Subject: ACP-323950-25 Graiguenamnagh Tinnahinch Flood Relief Scheme

Your Ref: ACP-323950-25

Re: Section 177AE application by Kilkenny County Council for Graiguenamnagh Tinnahinch Flood Relief Scheme

DRAWING TITLE
FLOOD RELIEF WORKS
UPSTREAM STORAGE AREA – DUISKE RIVER
FLOOD EXTENT MAP OF STORAGE AREA

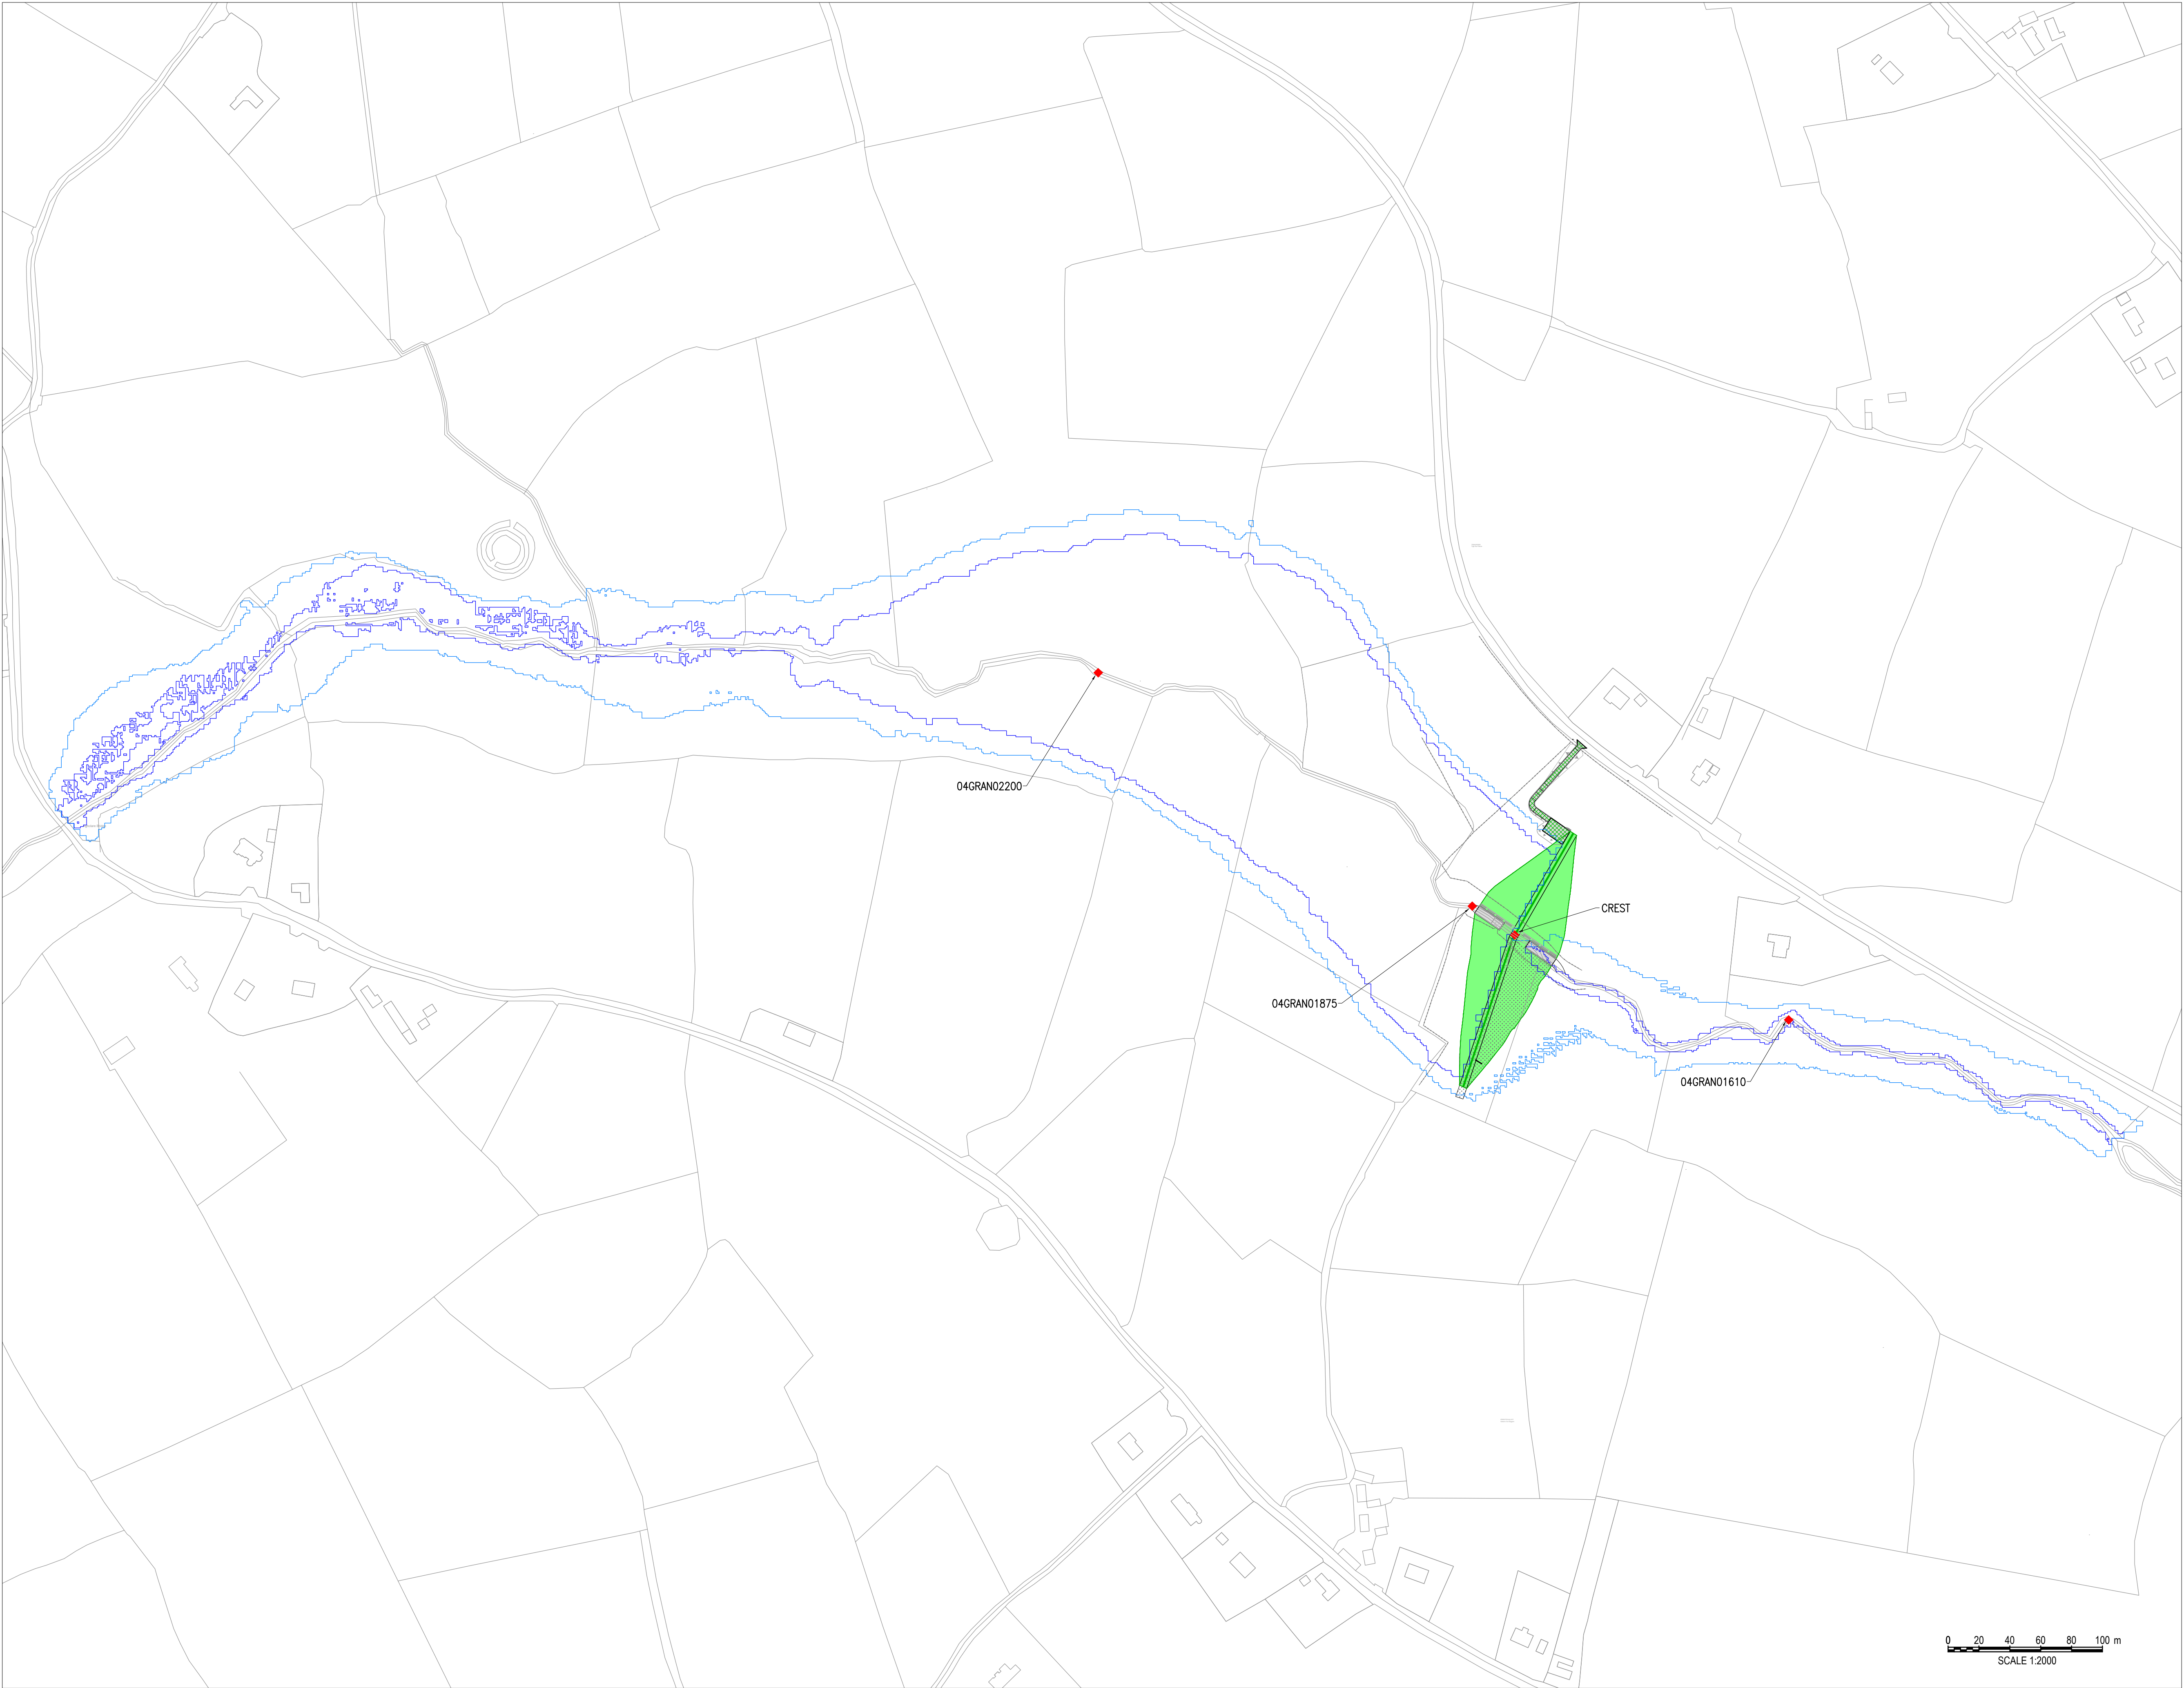
3. There are a number of flow control structures proposed in the upstream storage area. This will prevent the passage of otters, as is noted in section 10.4 of the NIS that *“Instream works will allow enough space for otters to pass through without having to divert onto land and back onto the watercourse downstream. This is not possible for the flow control structure in the upstream storage are, however, all other instream works will allow free passage of otters”*. Temporary river crossings involving the culverting of the stream is also proposed in Areas 1, 2, 3 and 4. Culverts can also prevent the passage of otters if they are not designed correctly and should include the provision of ledges to allow otters to pass through. Cylindrical culverts may guide otters to cross the temporary crossings, which could result in injury or mortality from passing vehicles. Guidelines for the Crossing of Watercourses during the Construction of National Road Schemes (National Roads Authority, 2005) must be followed to avoid any potential barrier to otter movements up and downstream from the River Barrow and its tributaries. An SSCO for QI otters is *“no significant increase in the number of barriers to connectivity”*. Assessing potentially significant impacts must be addressed in relation to the SSCOs for each QI habitat and species. This has not been sufficiently addressed within the NIS and the Department recommends that further information is requested in relation to this.

DRAWING
TITLE
SITE WORKS
ARBOREAL IMPACT GA LAYOUT

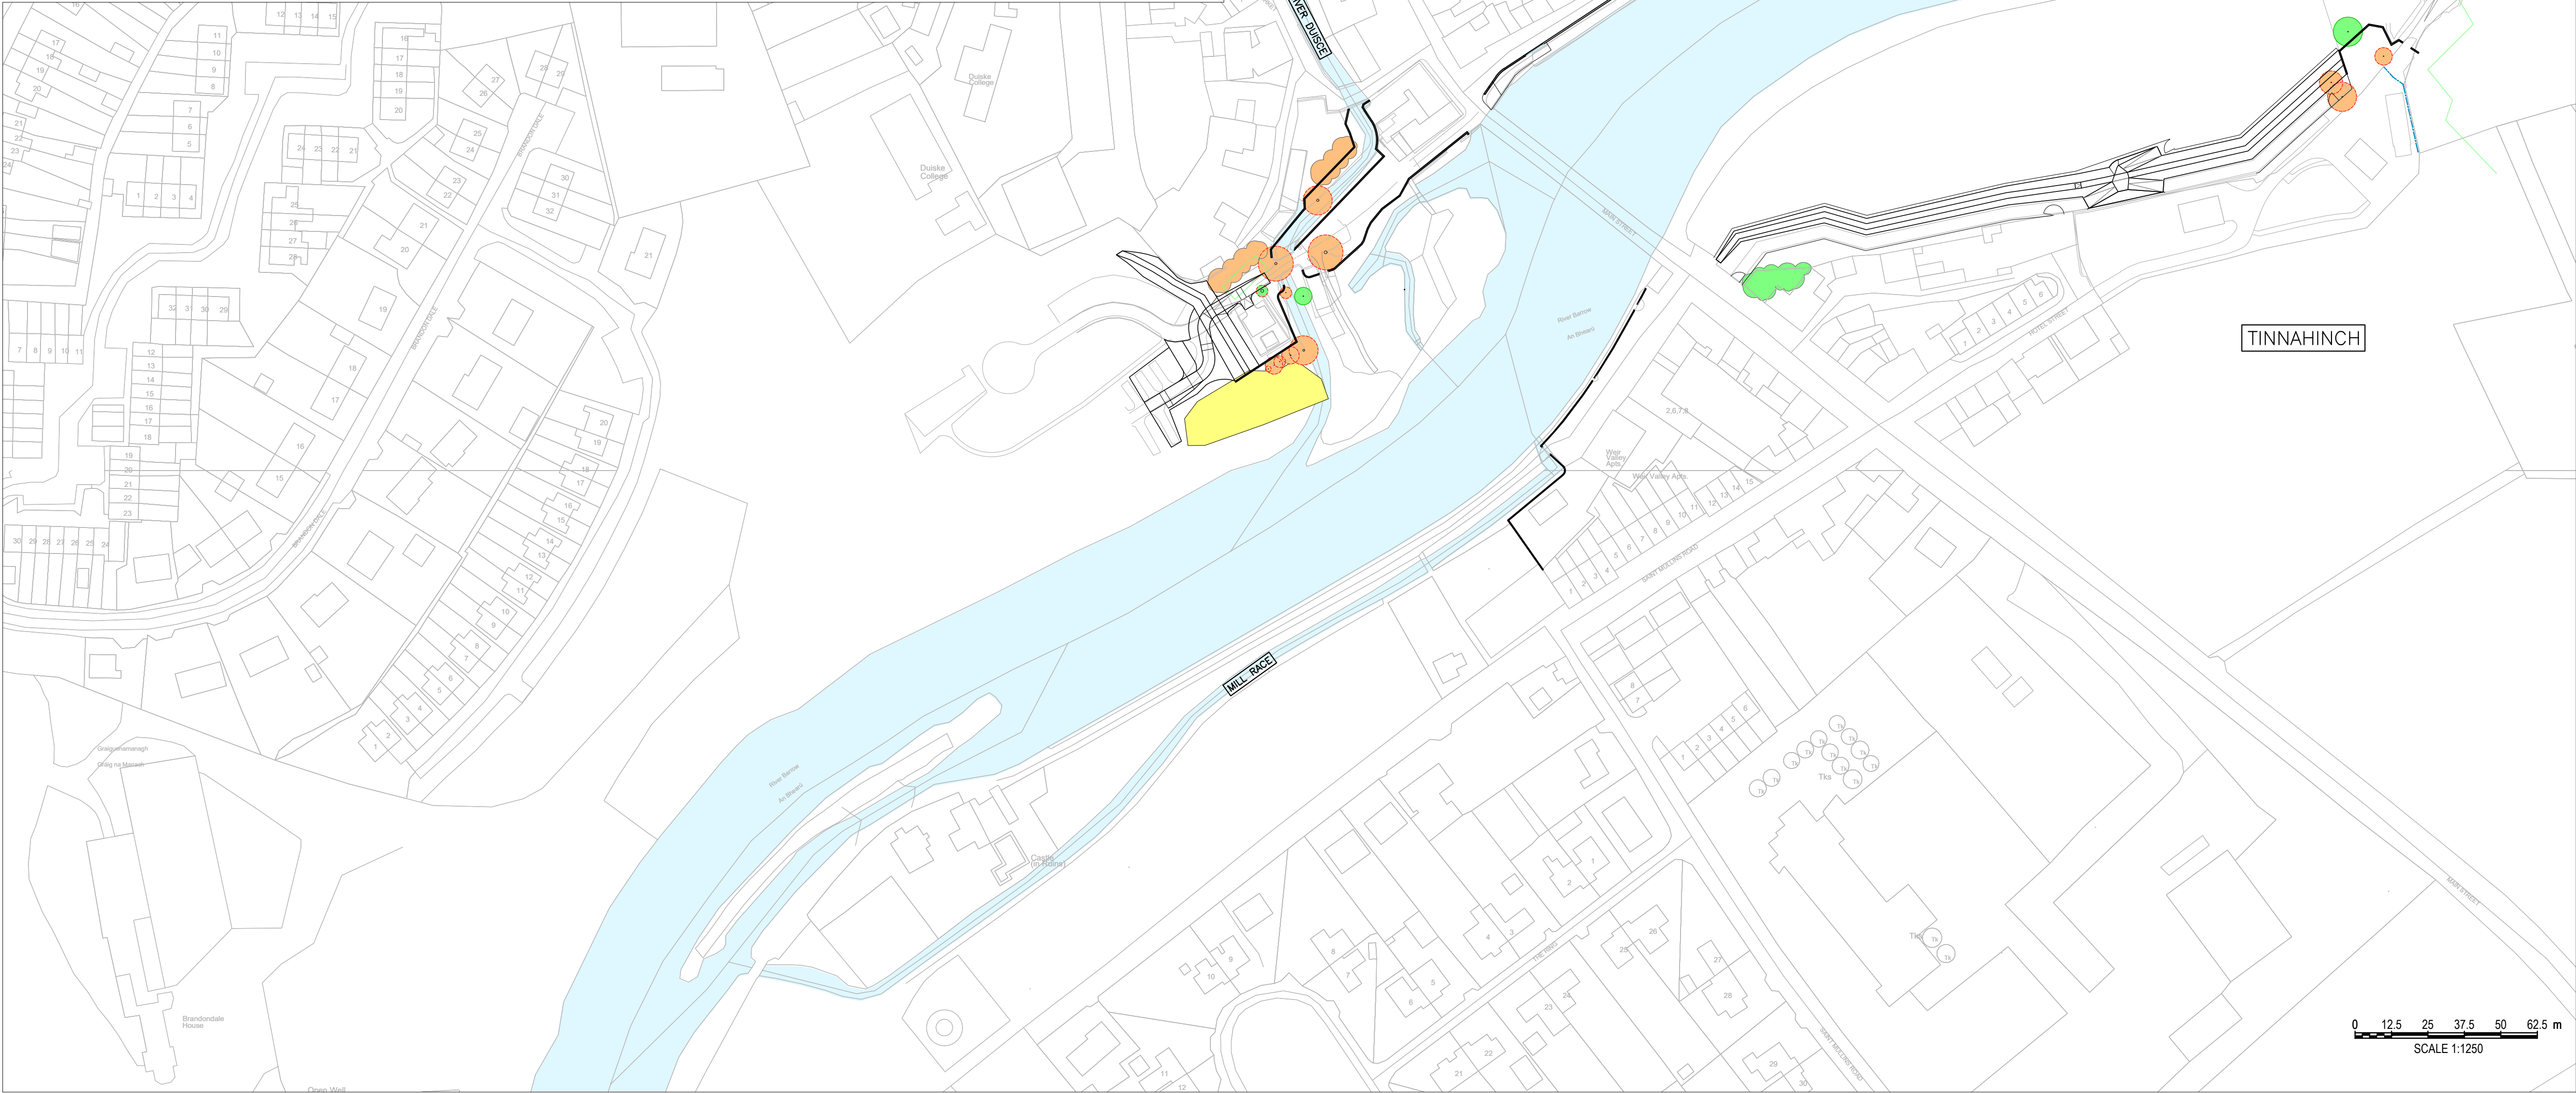
riparian habitat will be removed within and outside of the SAC, but it is noted that *“Approximately 728 m² of woodland is to be lost in total between the upstream storage area and the Graiguenamanagh town area. The upstream storage area will account for approximately 630m² of lost woodland”*. It needs to be quantified how much vegetation will be lost, so that the mitigation is sufficient to ensure that the project will not adversely affect the integrity of the River Barrow and River Nore SAC in view of its conservation objectives. In addition, a 10 metre riparian buffer on both banks of a waterway is considered to comprise a critical part of the otter habitat², which includes ex-situ habitats outside of the SAC and this should be included in the calculations. Mitigation to address this permanent and temporary (dependent on location) loss of habitat is not proposed within the NIS. There should be no net loss of habitat within the proposed scheme. The Department recommends further information in relation to this.

DRAWING
TITLE
SITE WORKS
BIODIVERSITY ENHANCEMENT MEASURES

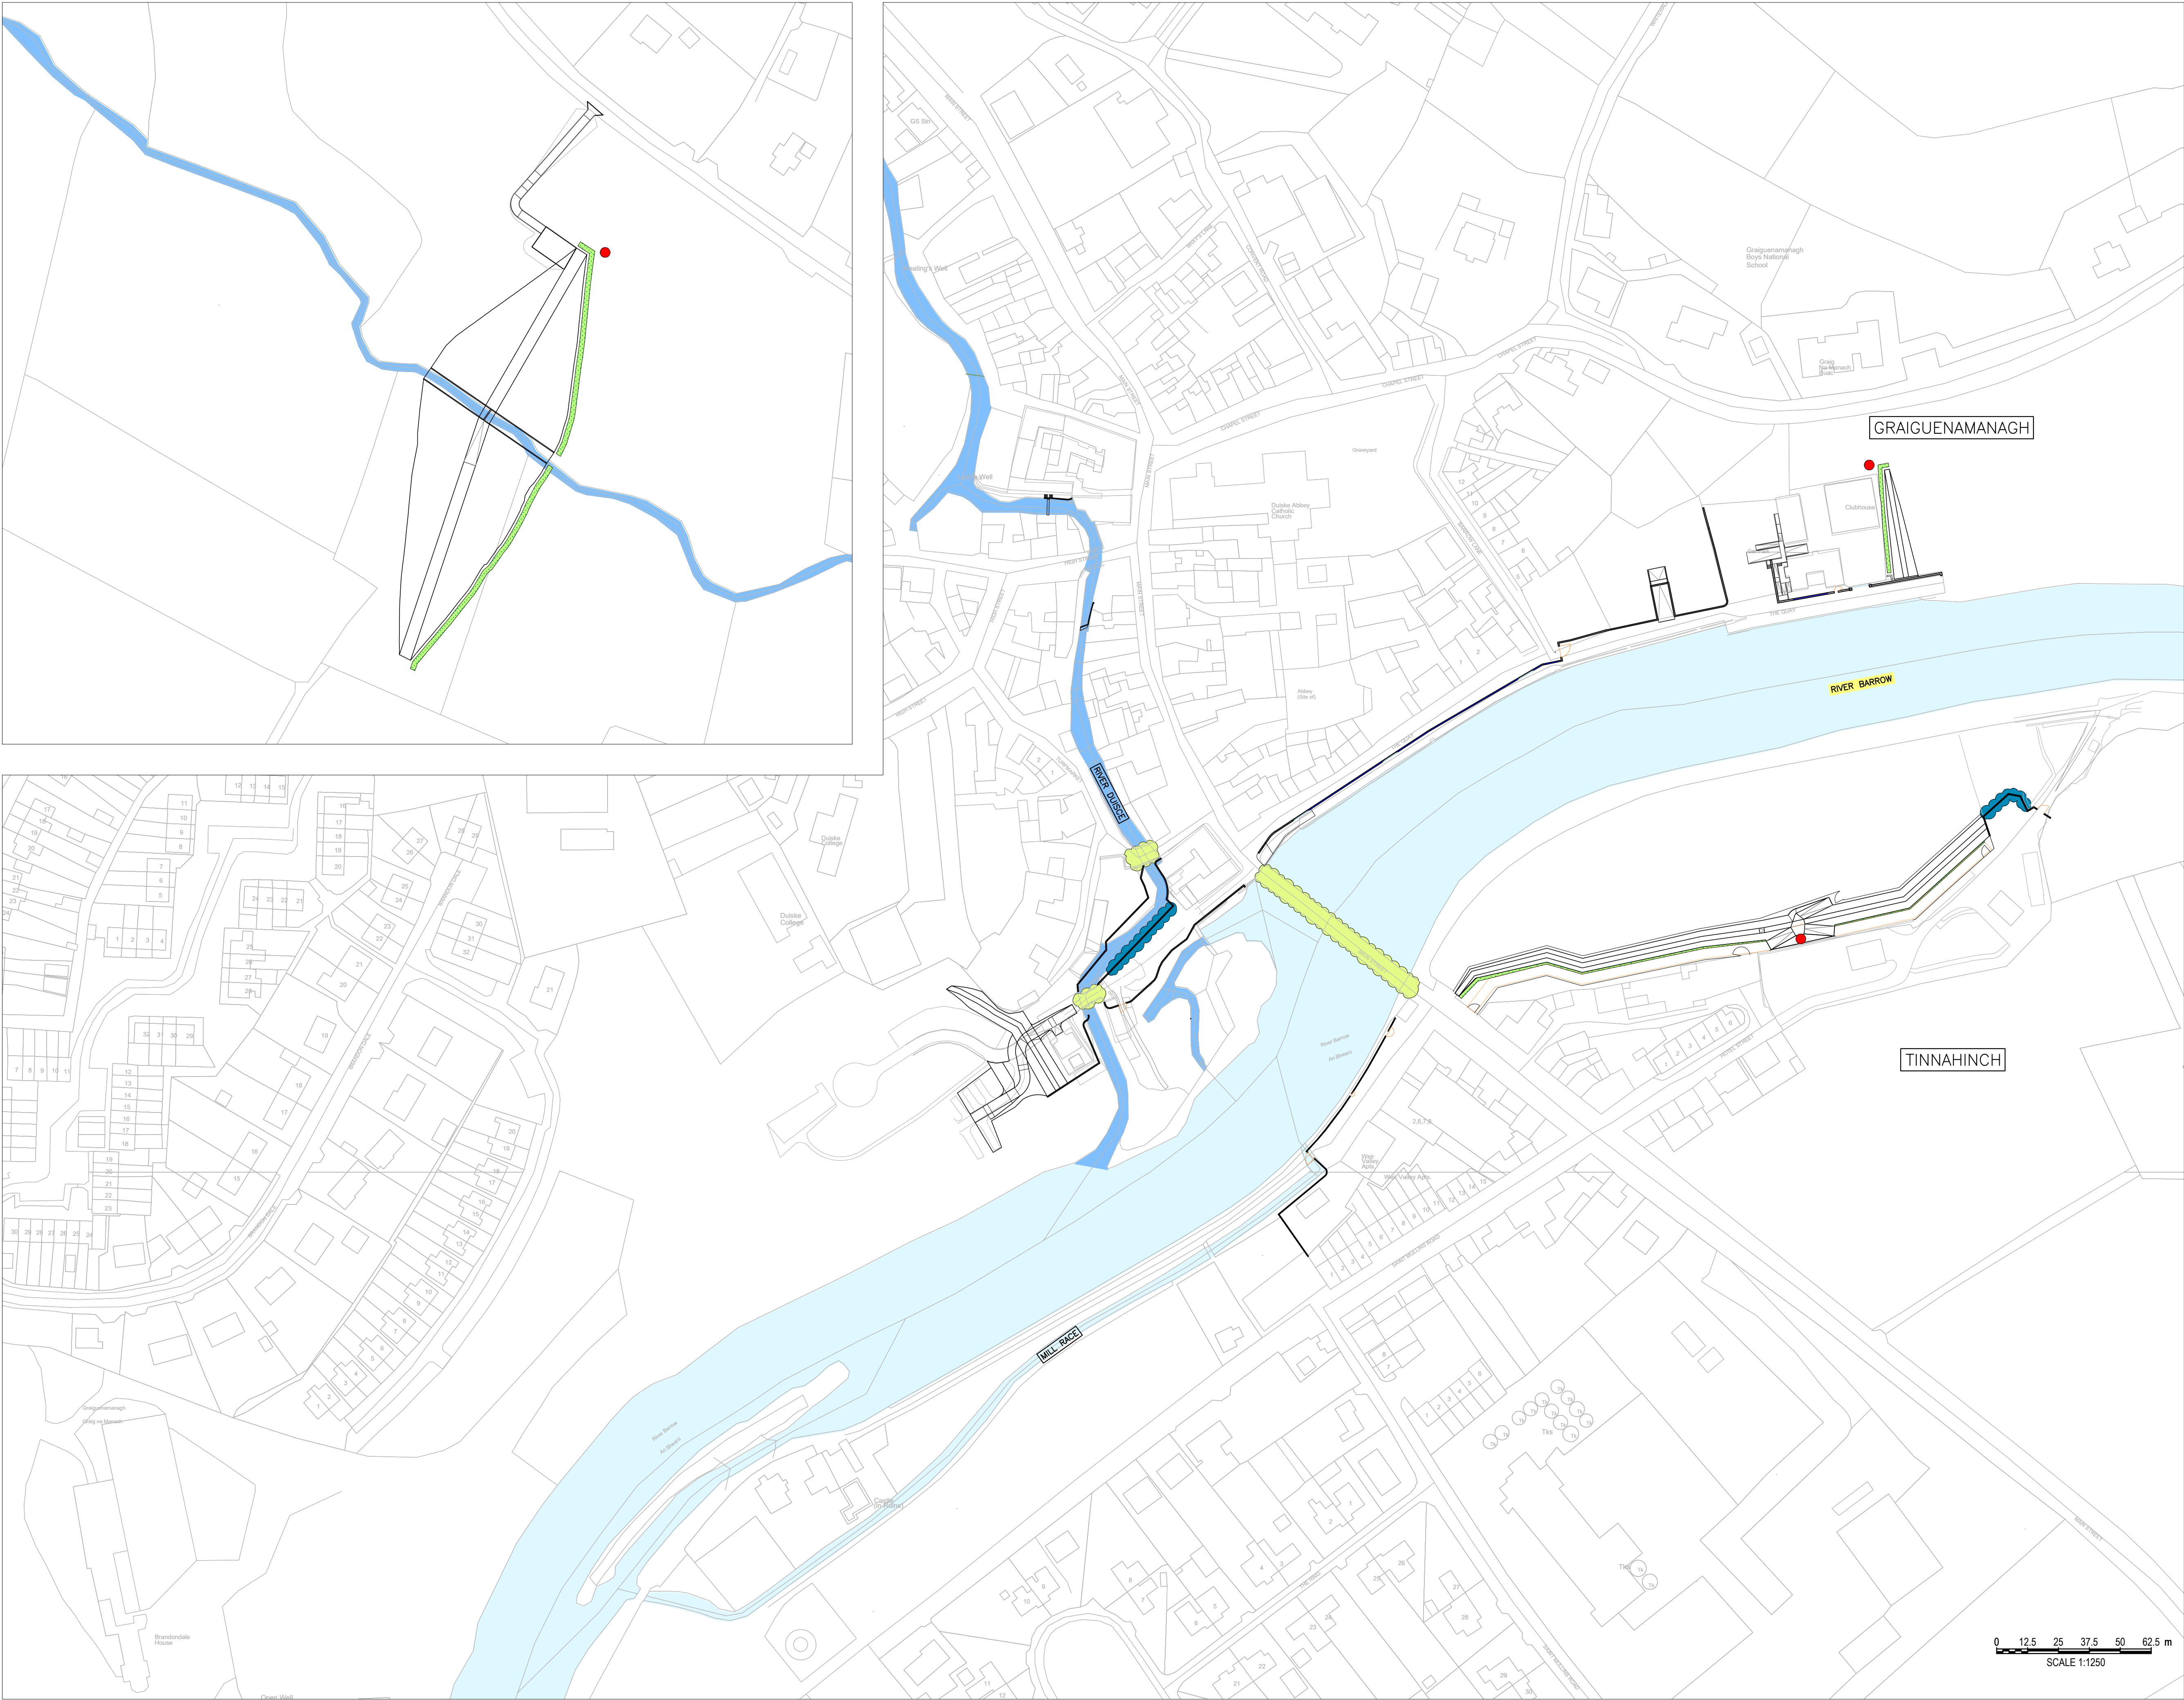
It is noted that "pollinator meadows will be incorporated into the land at the embankment at Hotel Street in Tinnahinch and the clubhouse in Graiguenamanagh, with the meadow placed on the dry side of the embankment. The Department recommends only native species are planted in these areas. Planting wildflower seed mixes should be avoided as these are not regulated and can be detrimental to biodiversity. Simple changes to grass management practices can be more effective and less costly. Creating ornamental meadows, margins and 'short-cut floral lawns' is considered a gardening or horticultural action. This may help flower visiting insects, but does not hold the same value for the natural environment as creating a natural grassland. Natural grasslands develop over millennia due to specific local site conditions; geology, climate, soil, natural seed bank and past management practices. It is
